Application No: M/75/20/PL
Site Address: 13 Elm Drive Elmer Middleton-On-Sea PO22 6JE
Description of works: Demolition of existing dwelling & erection of replacement dwelling. This site is in CIL Zone 4 & is CiL Liable as new dwelling.

Thank you for your internet representation made on 11th November 2020 which has been recorded as an objection with the comments as follows:

Site Plan 1:100

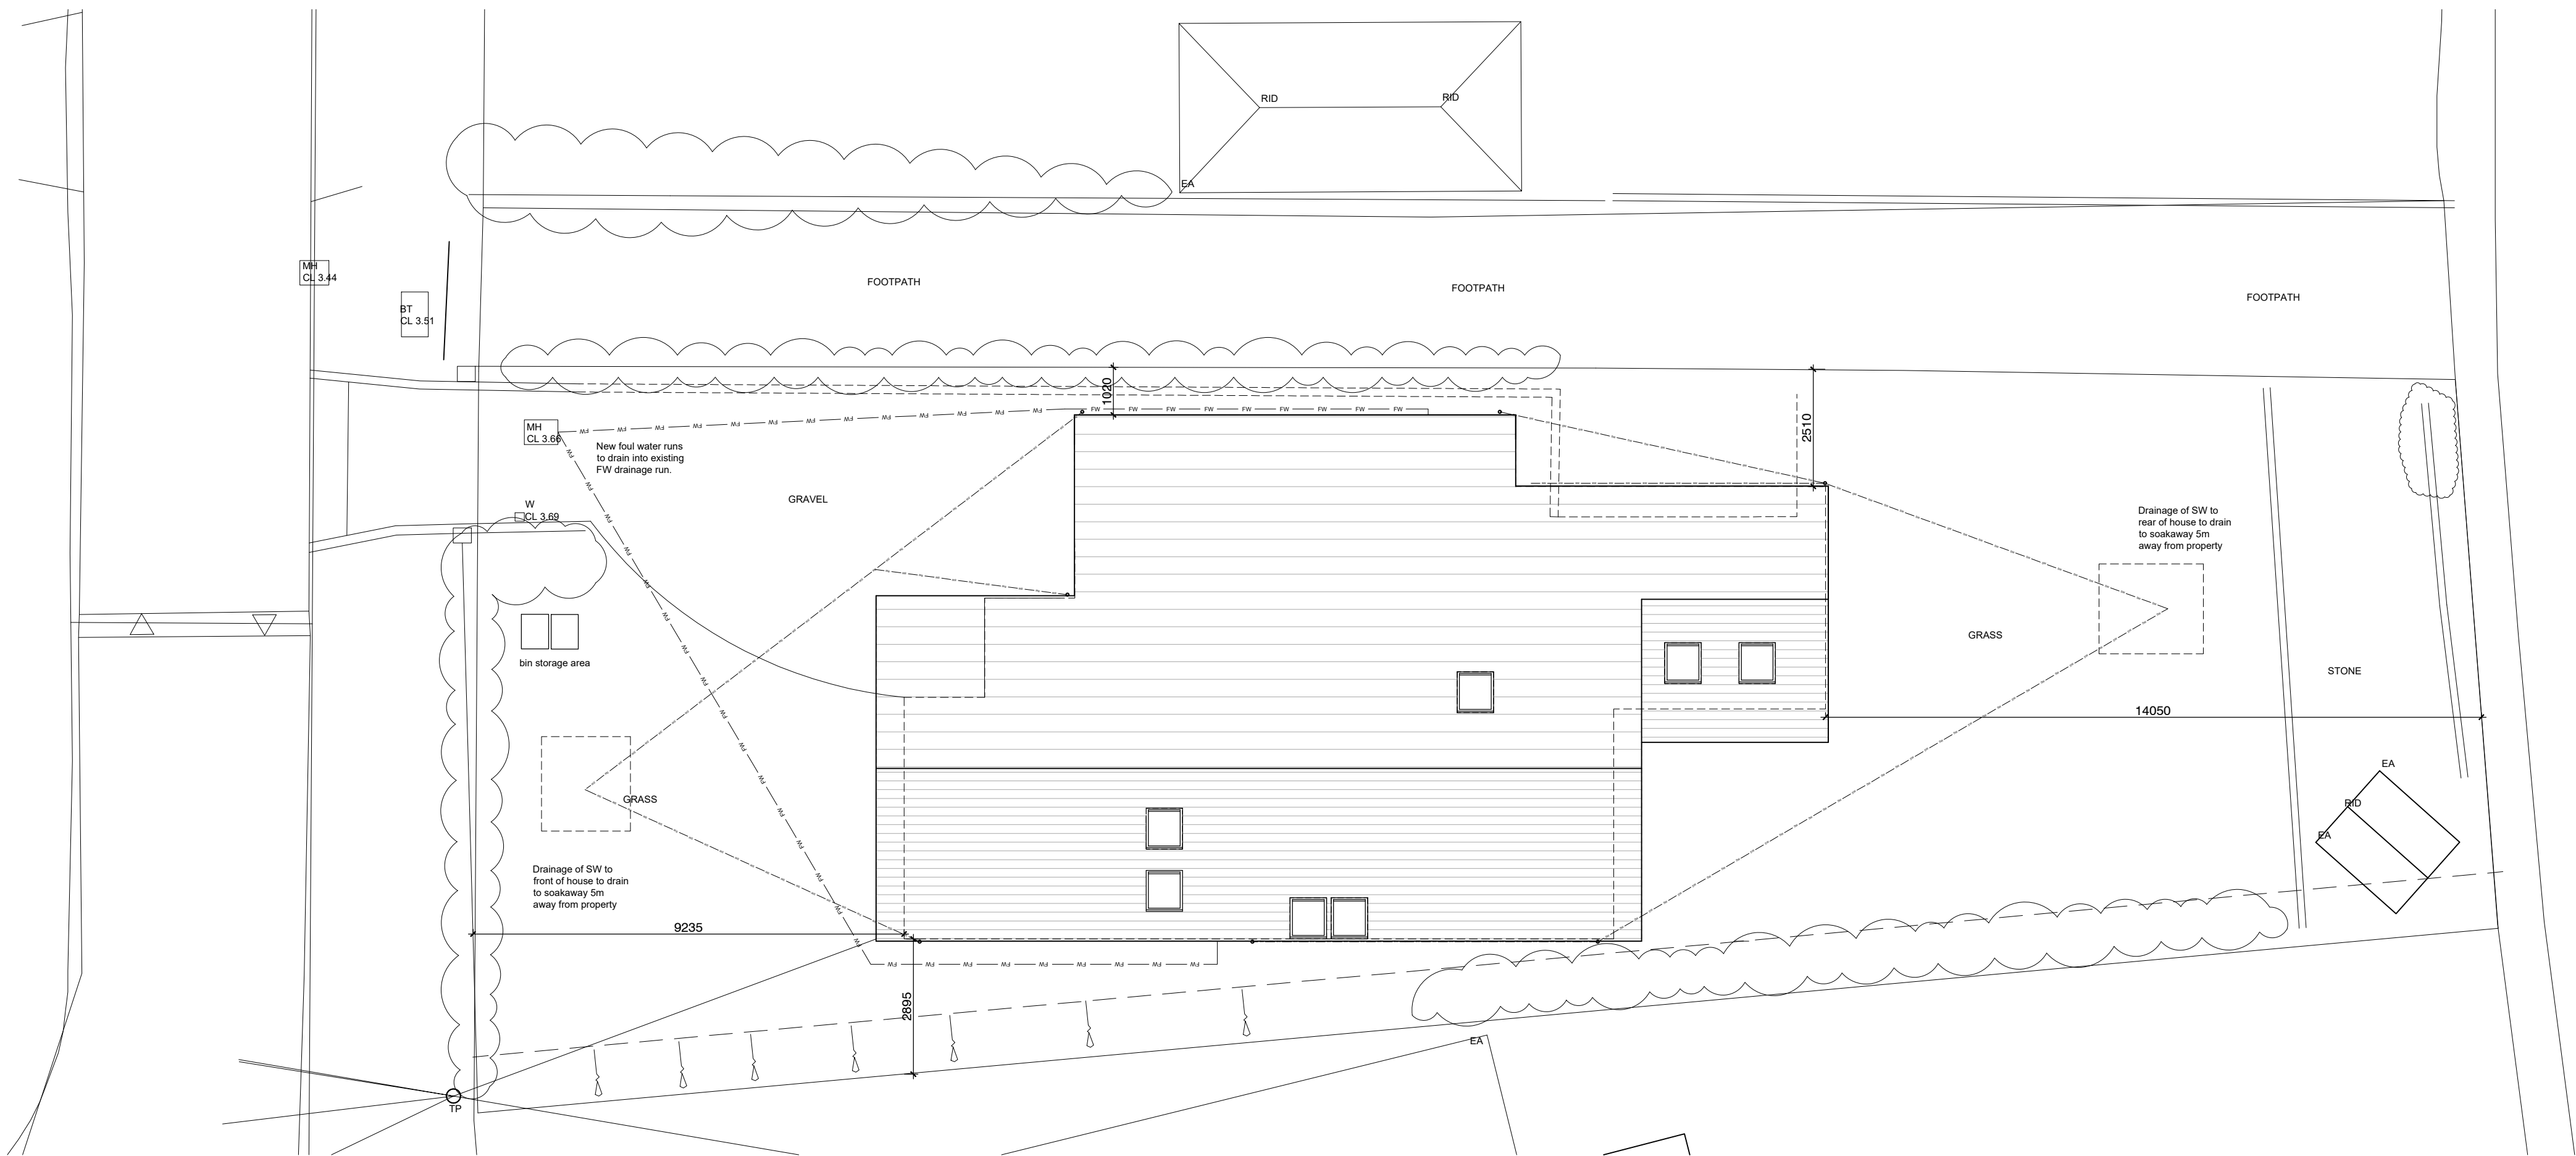
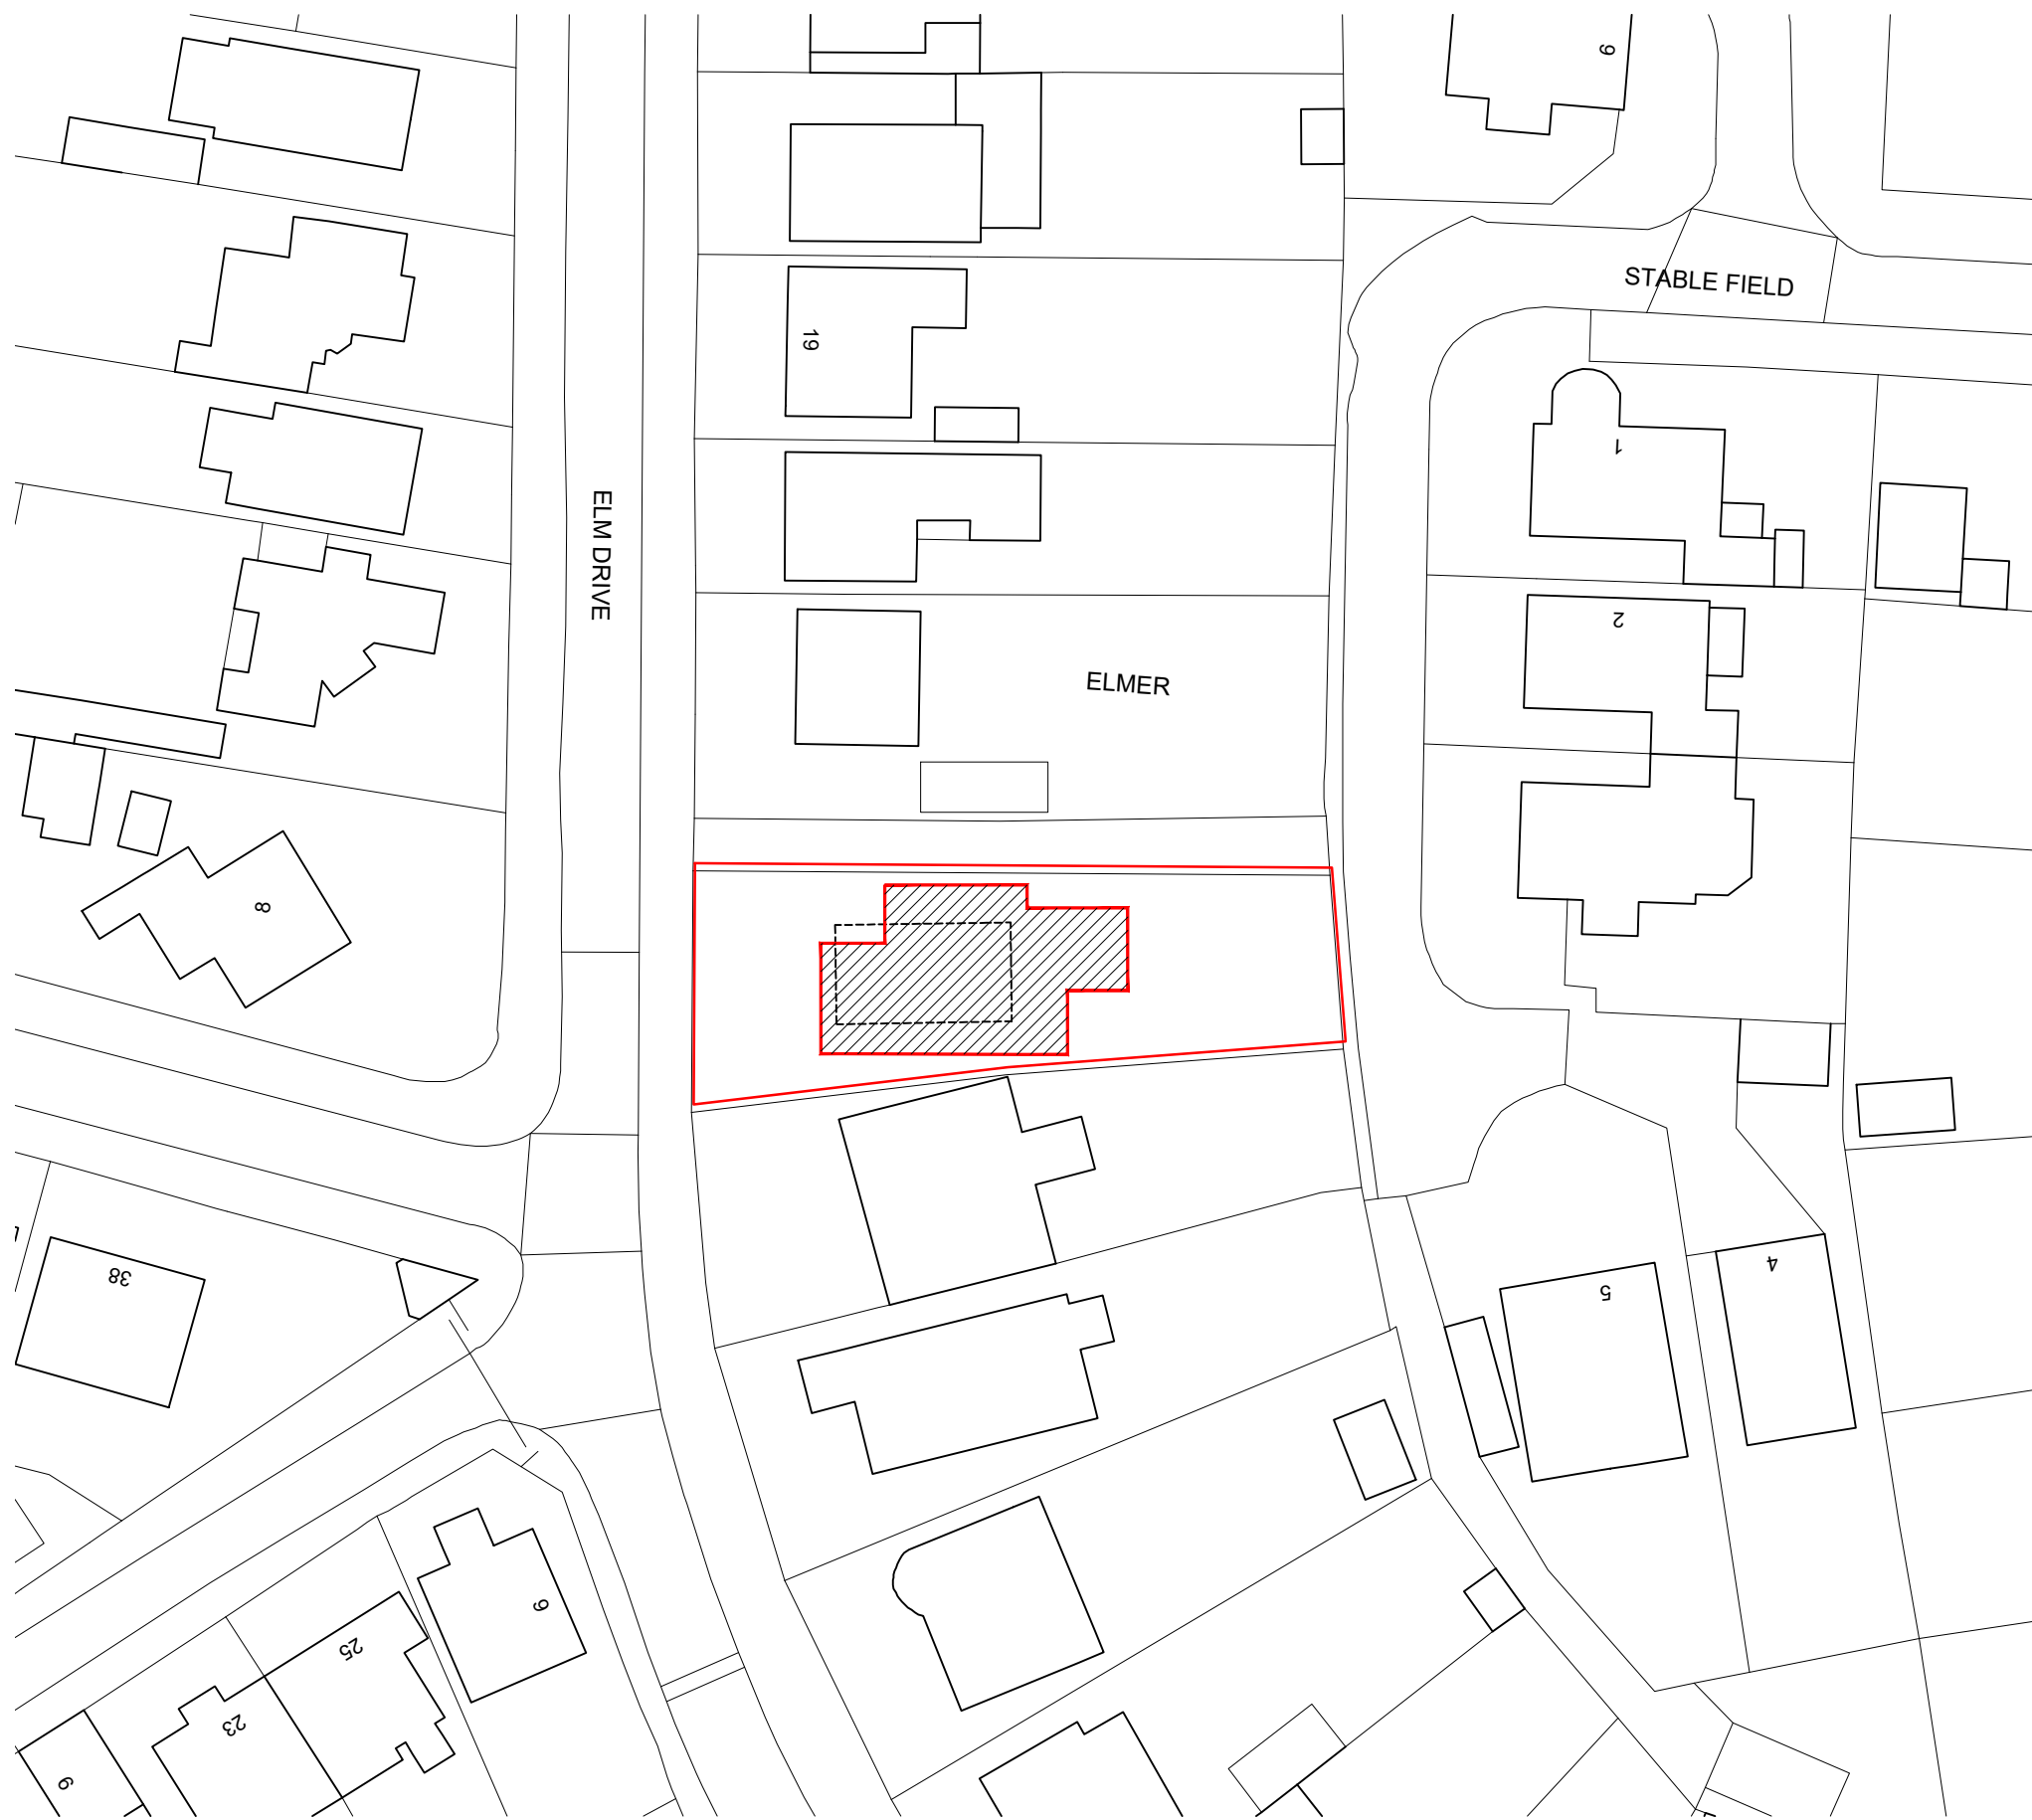
- 1) We would query whether the eastward extension of build towards our property is permissible under planning regulations and guidelines. Whilst adding a further floor may seemingly be allowable we do not believe that other newly built properties in this area have been permitted to significantly increase their footprint at original ground level. The proposed eastward extension here into the current garden area takes the rear of the property out of line with other existing properties in Elm Drive and, fundamentally, creates a significant overlook of properties in Stable Field.

- 4) We would seek confirmation that access to the property would be solely from Elm Drive and that no pedestrian or vehicular access to Stable Field shall be permitted - either during the construction process or subsequently. That is the case currently and applies likewise to other properties in Elm Drive whose back gardens abut on to Stable Field

Eastern Elevation

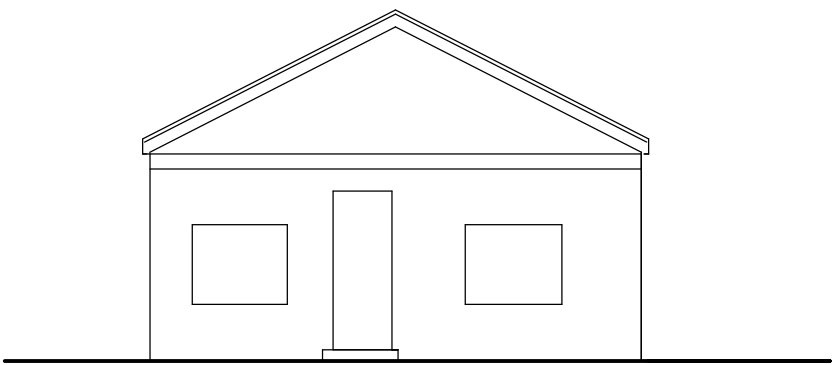
Finally our principal objection is the overlook consequences for those properties quite close by in Stable Field - and I trust that you will consider those very carefully.
